Addendum No. 1

RE: Contract # C204182

Dare County (R-5014)

SR 1217 (COLINGTON RD) FROM DEAD END TO US-158 (CROATAN HWY) IN
KILL DEVIL HILLS.

THRUST COLLAR AND THRUST BLOCK NOTES

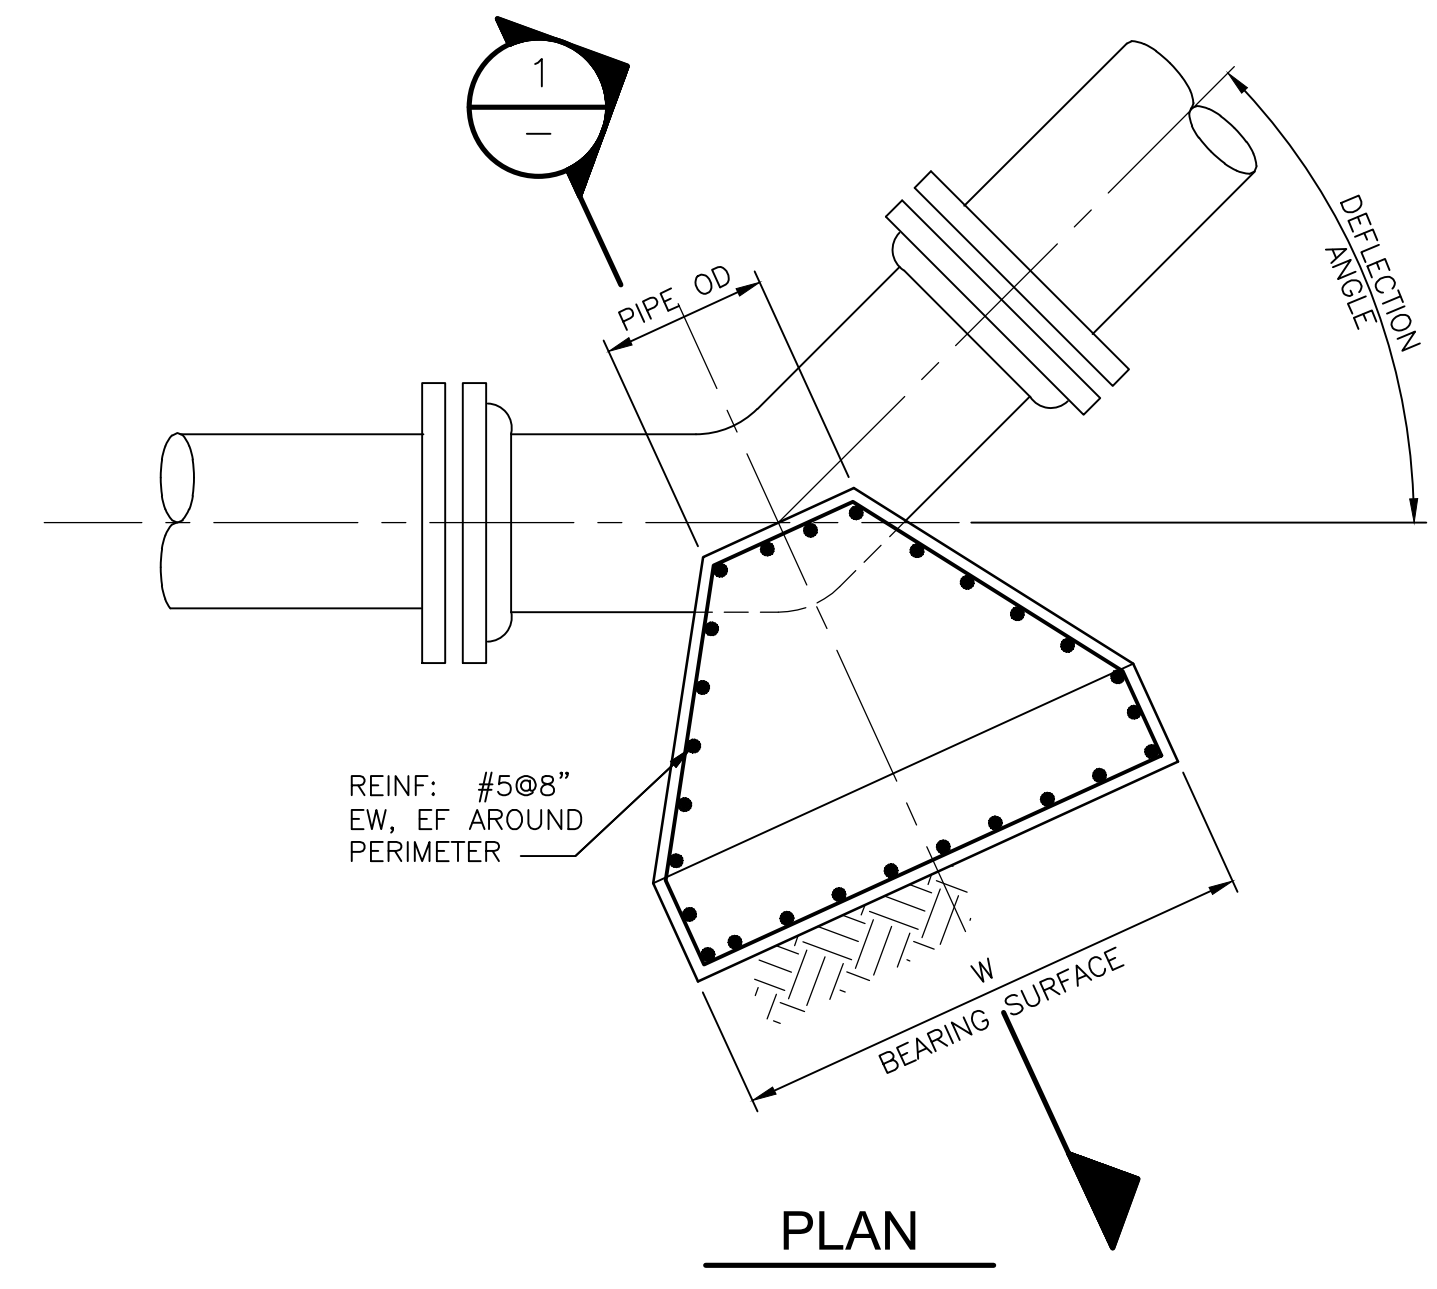
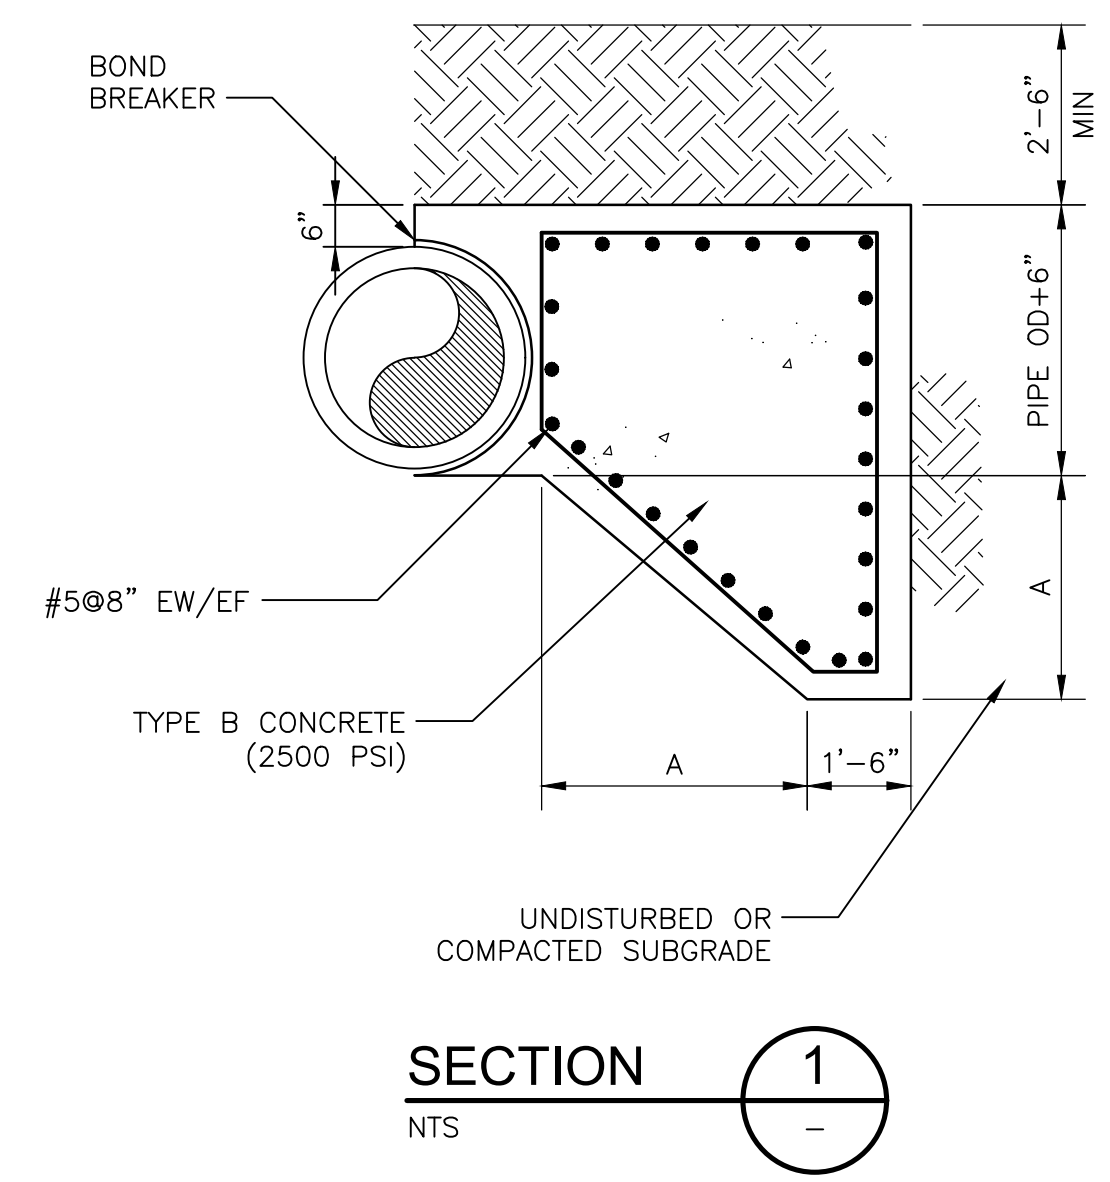
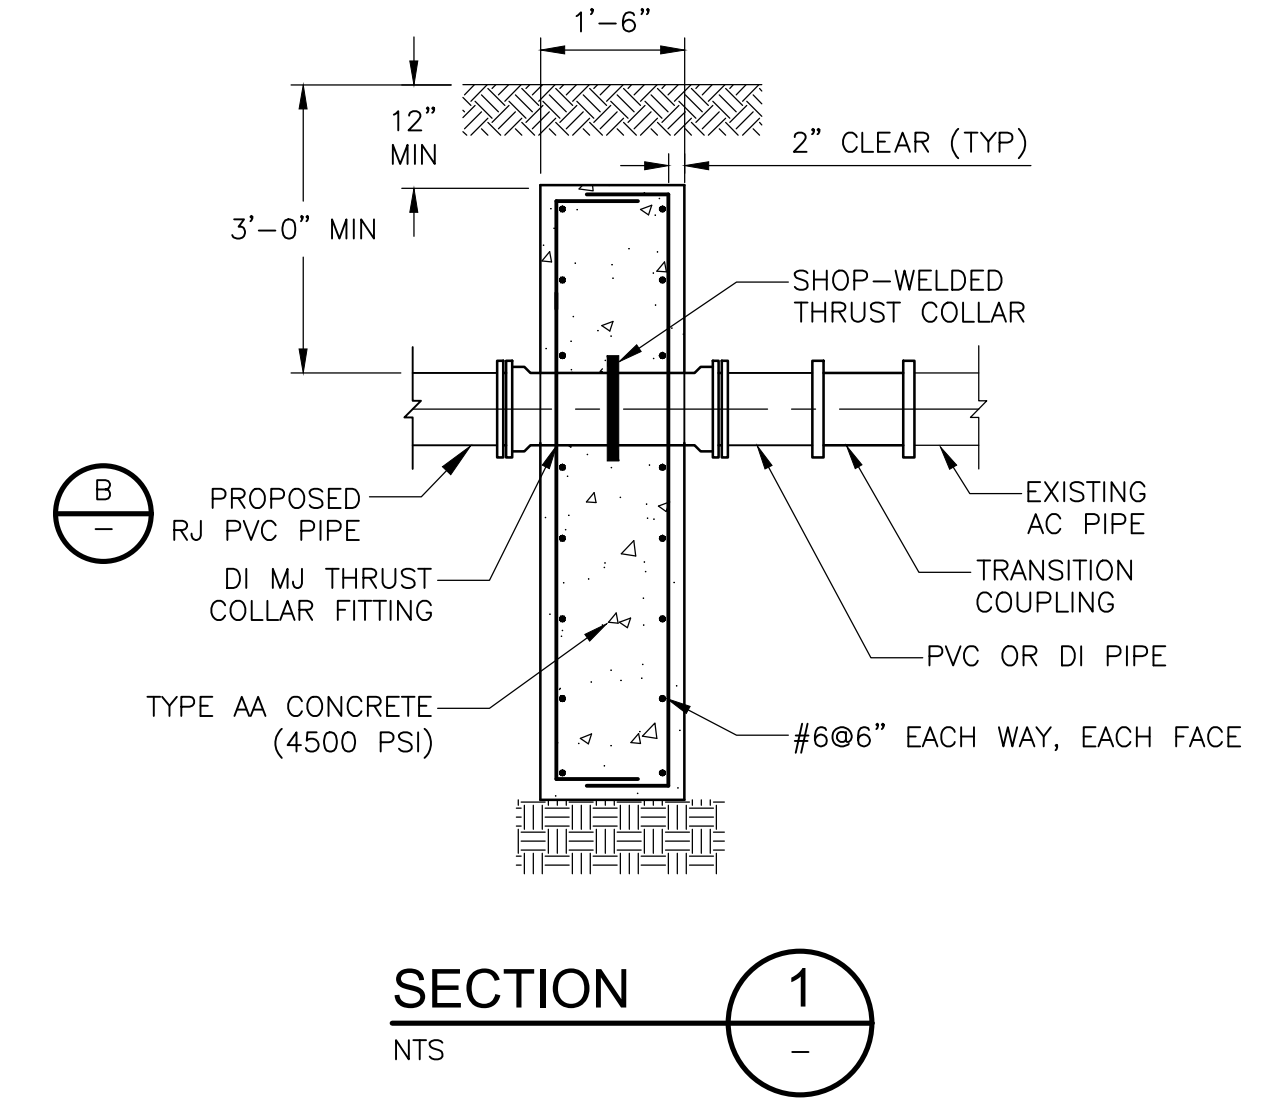
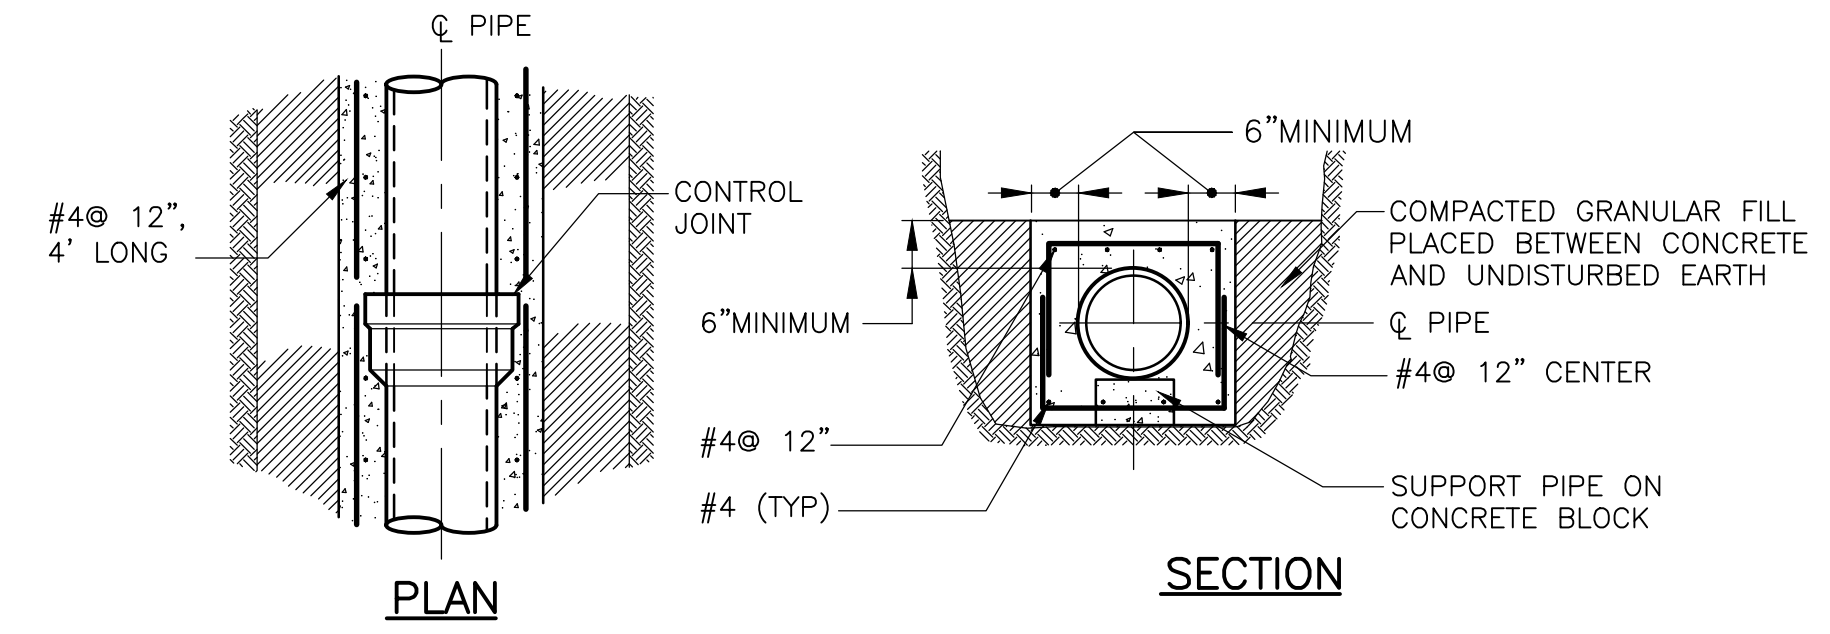
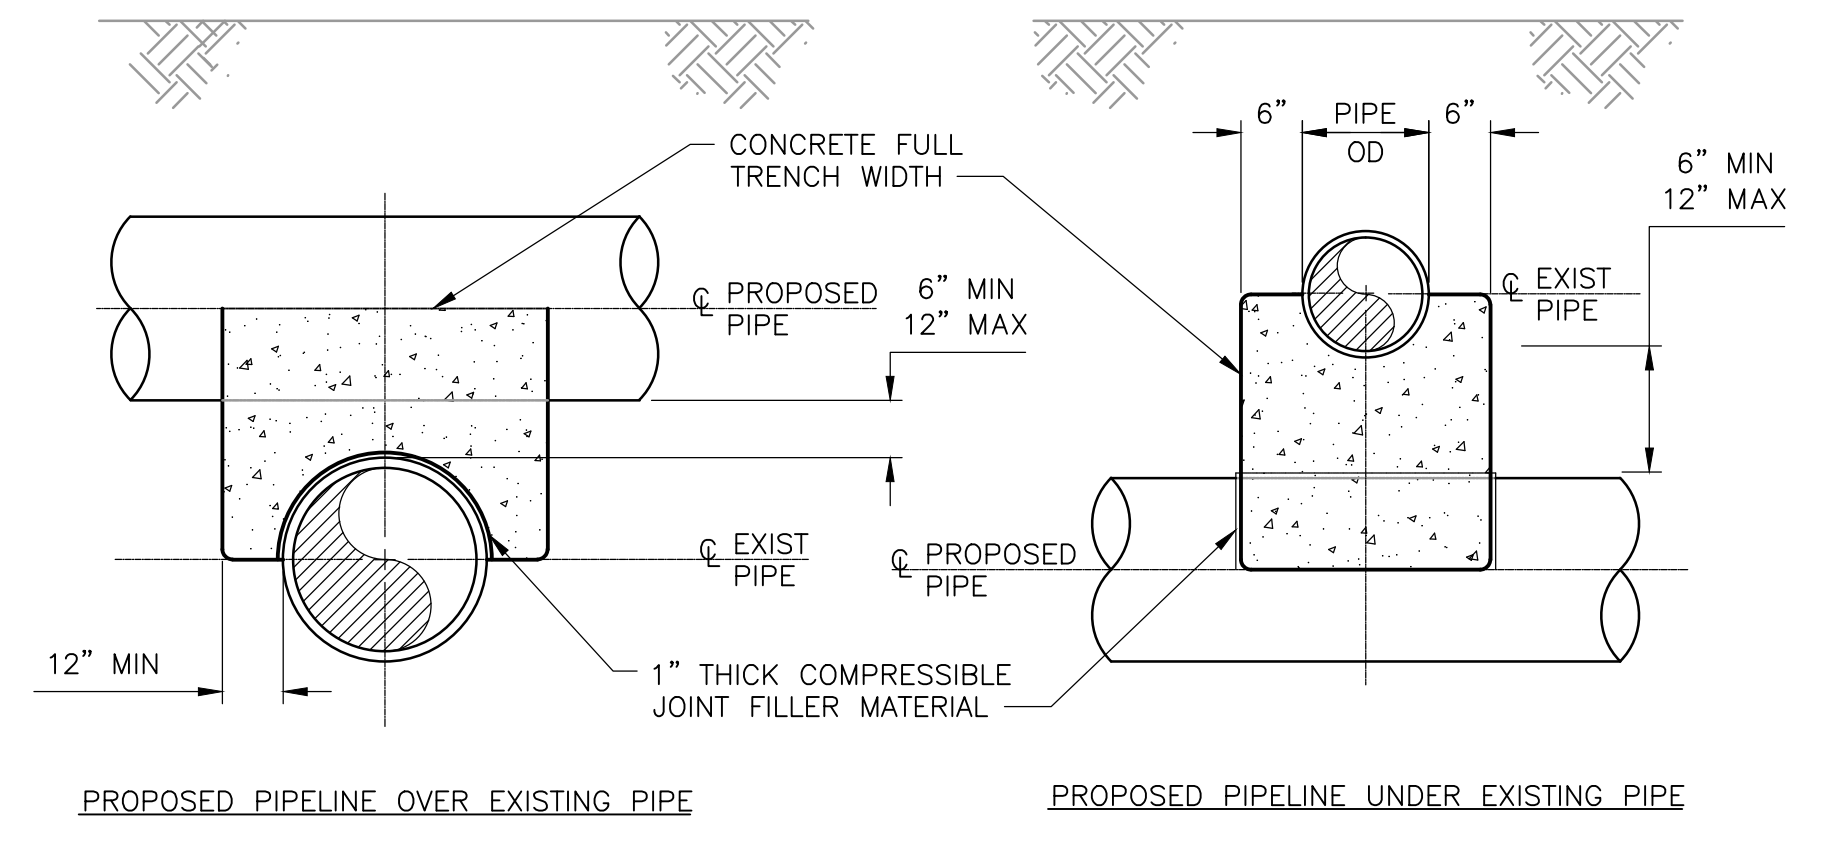
Sheet No.	Revision
UC-3E	Removed notes 4, 5, 7, 8 from the "Thrust Collar and Thrust Block Notes".
